From: Gareth Ryman [REDACTED]
Sent: 10 October 2016 10:53
To: Planning.Responses
Cc: David Innes
Subject: BR/214/16/DOC - University of Chichester Upper Bognor Road Bognor Regis PO21 1HR

2 Elevation F2 (General Arrangement)
1 : 100

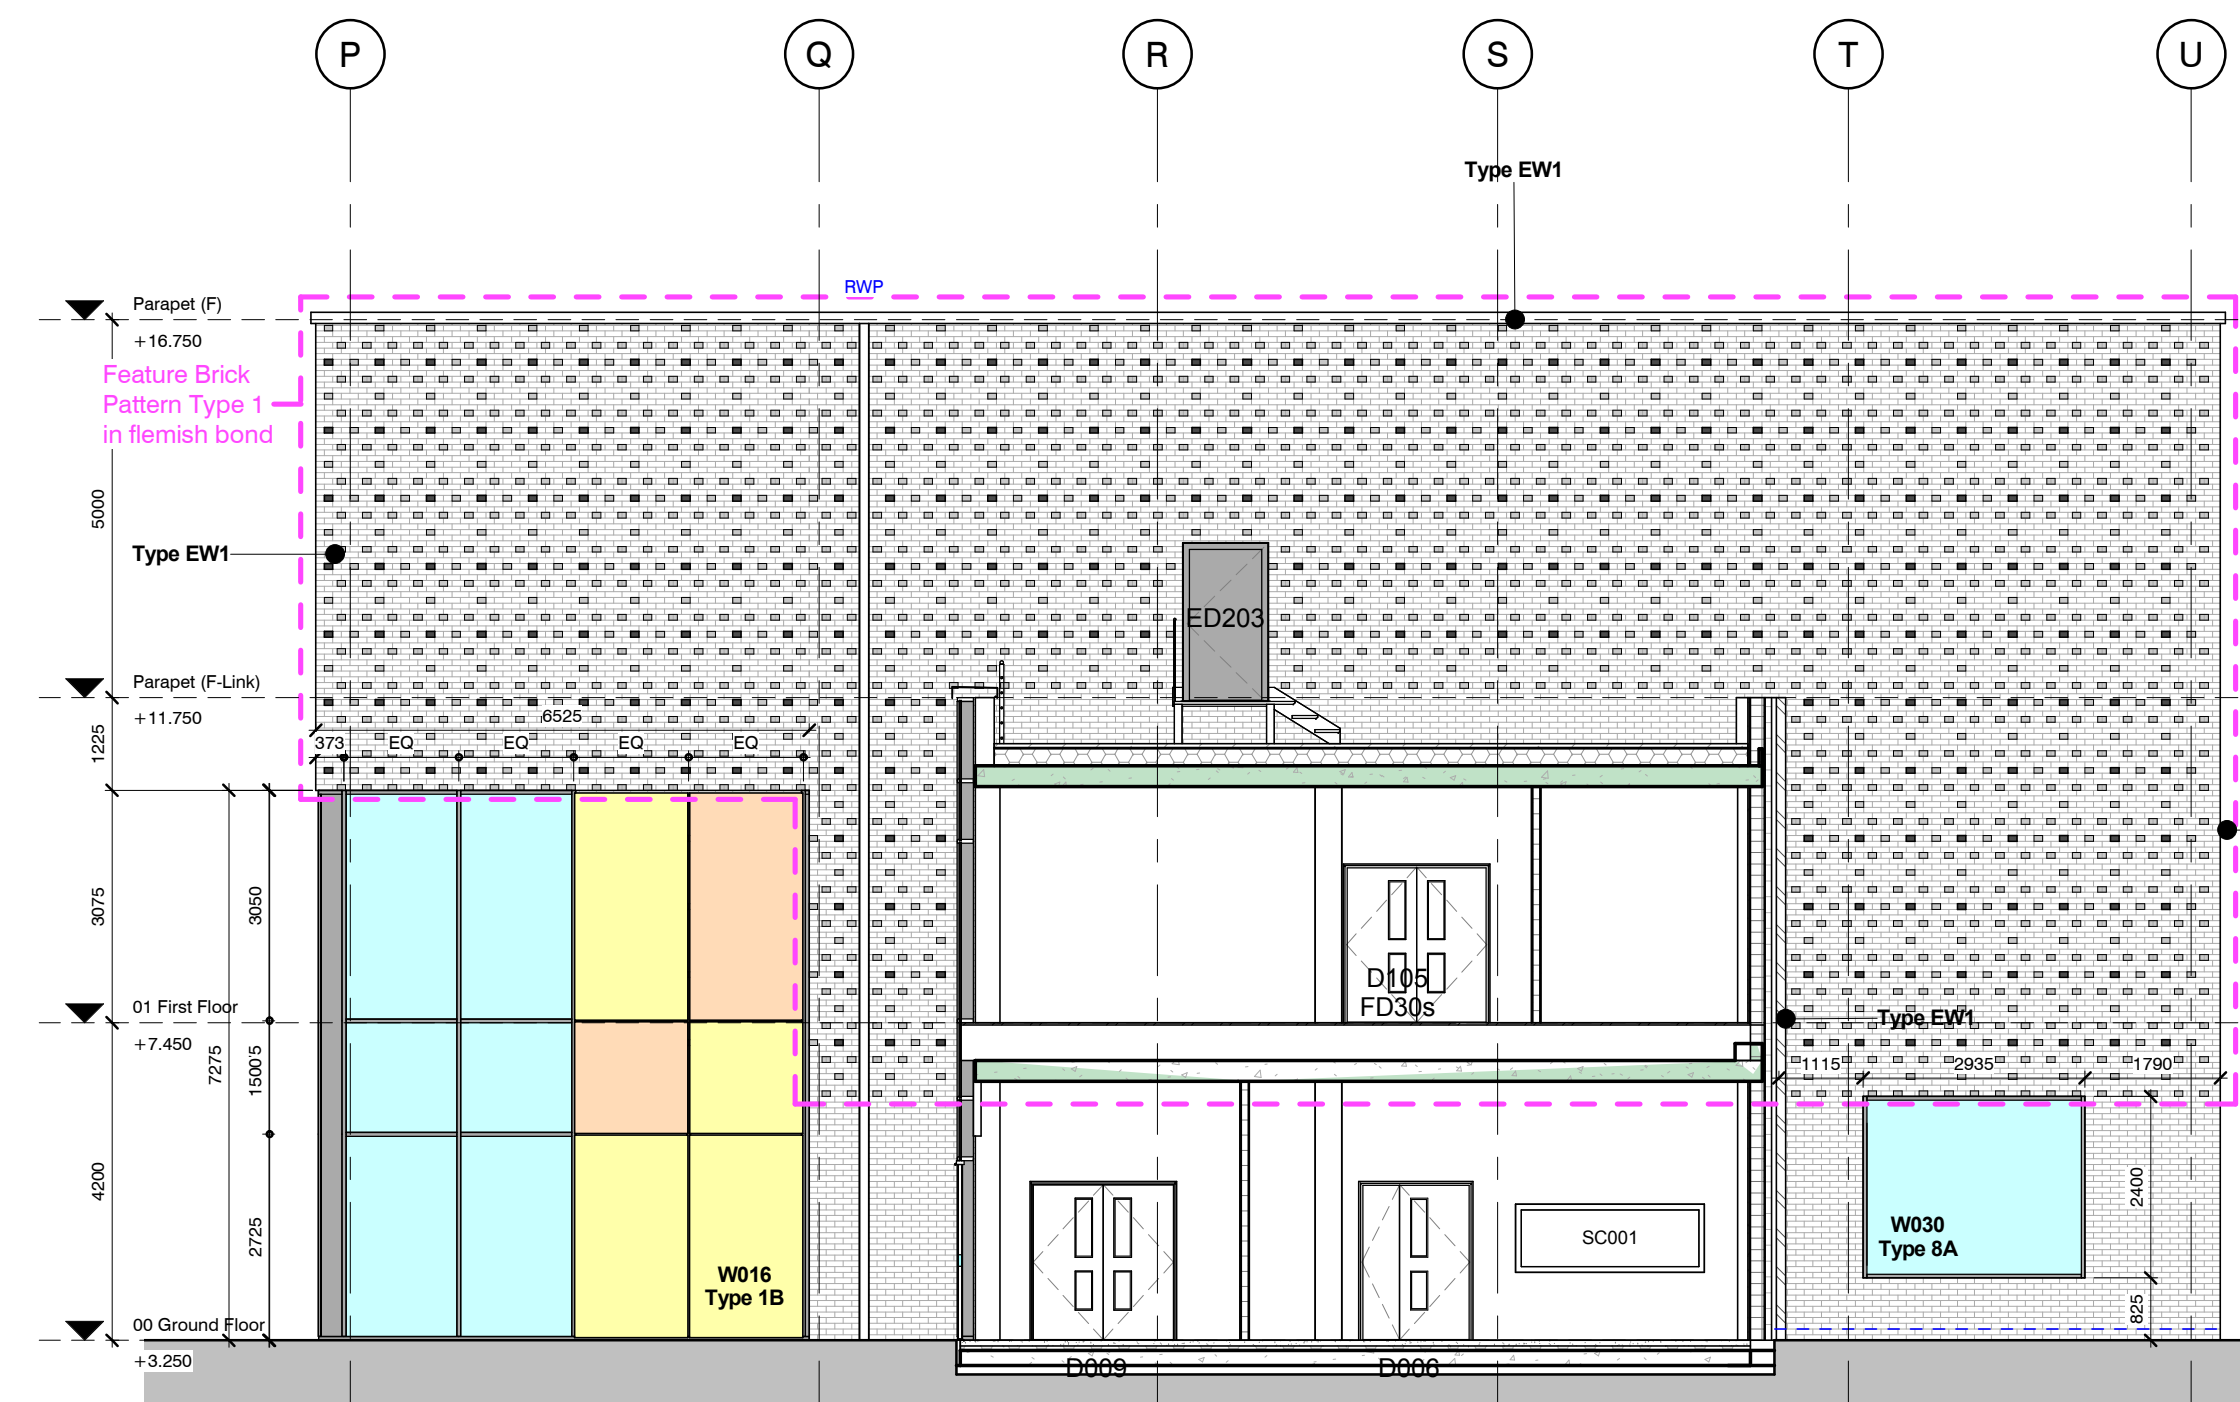
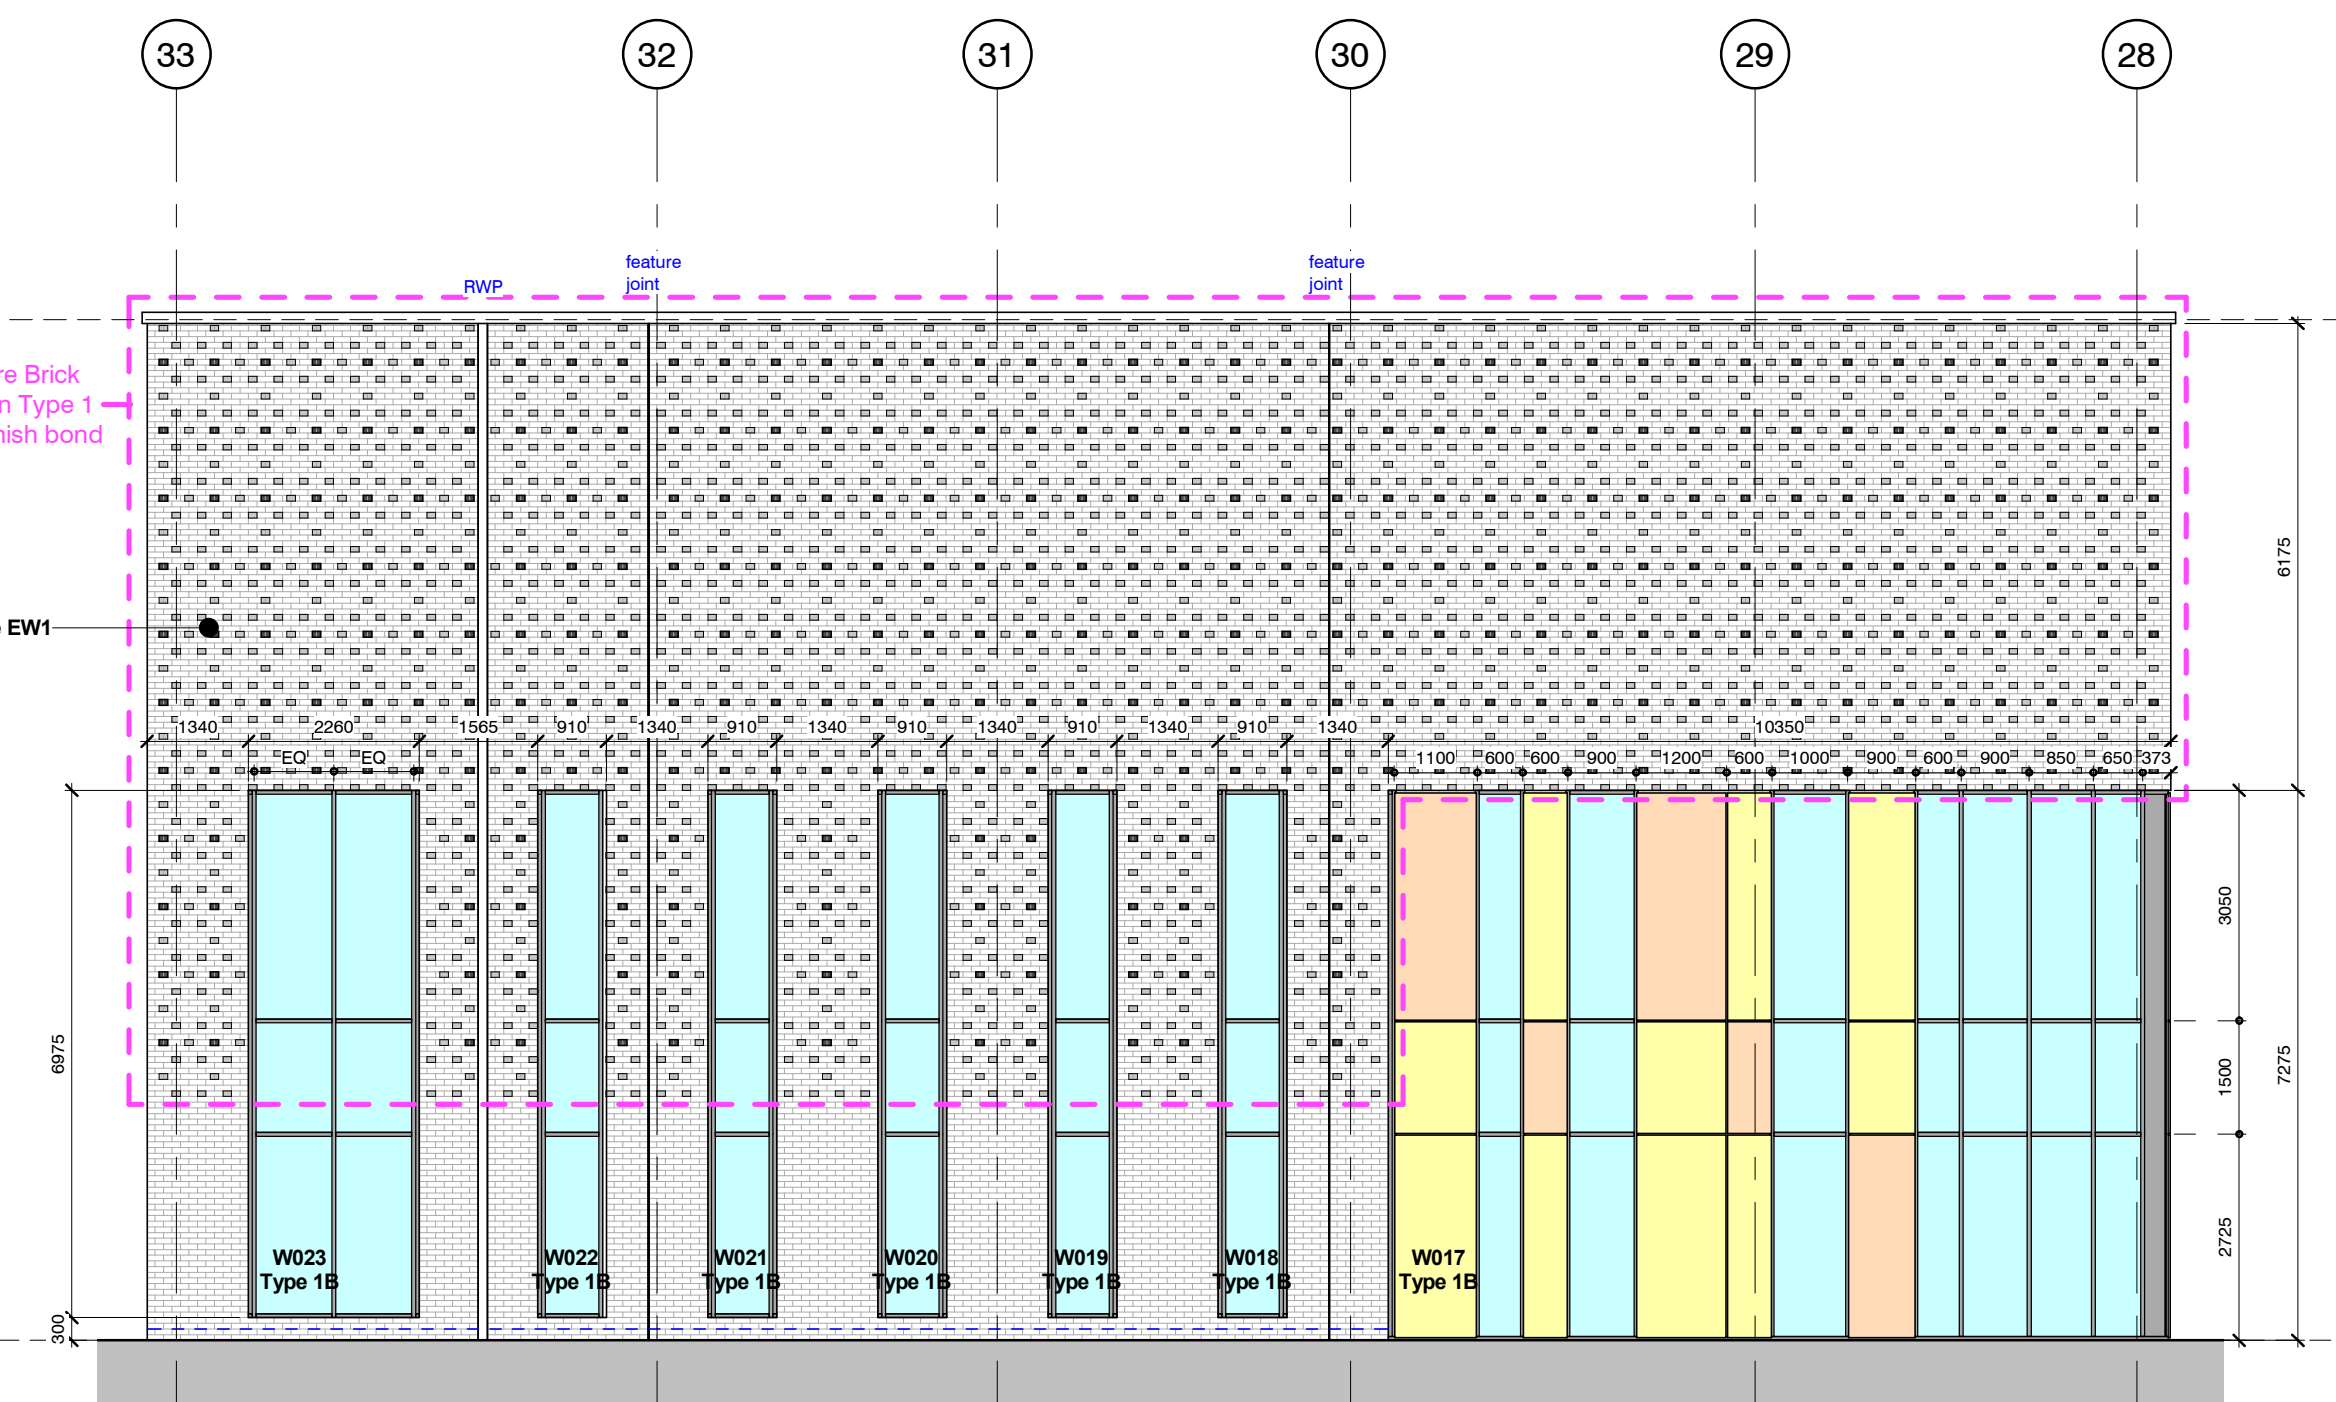
We would like to see the placement of 5 nesting opportunities for birds (species such as swallows, swifts and housemartins), to replace any potential loss of roosting/nesting provision. Along with 2 bat roosting structures being put on/around the building. Appropriate designs can be found in the publication "Designing for Biodiversity: A technical guide for new and existing buildings". Ecological advice should be sort in when deciding where and which of these structures should be placed for maximum effectiveness, because thermal tolerances of each species are very important. Lighting will need to be kept to a minimum, as lighting levels have a effects on nocturnal species such as bats, flying invertebrates and various mammal species. To this effect we would wish to see a lighting plan for conditioning. There will need to be a plant scheme, containing native plants only submitted for conditioning. We ask that applicants/consultants please share their survey results with [Sussex biodiversity records centre](#). If possible reed bed/fen bed soakaways should be used on site to provide drainage and additional wildlife habitat.
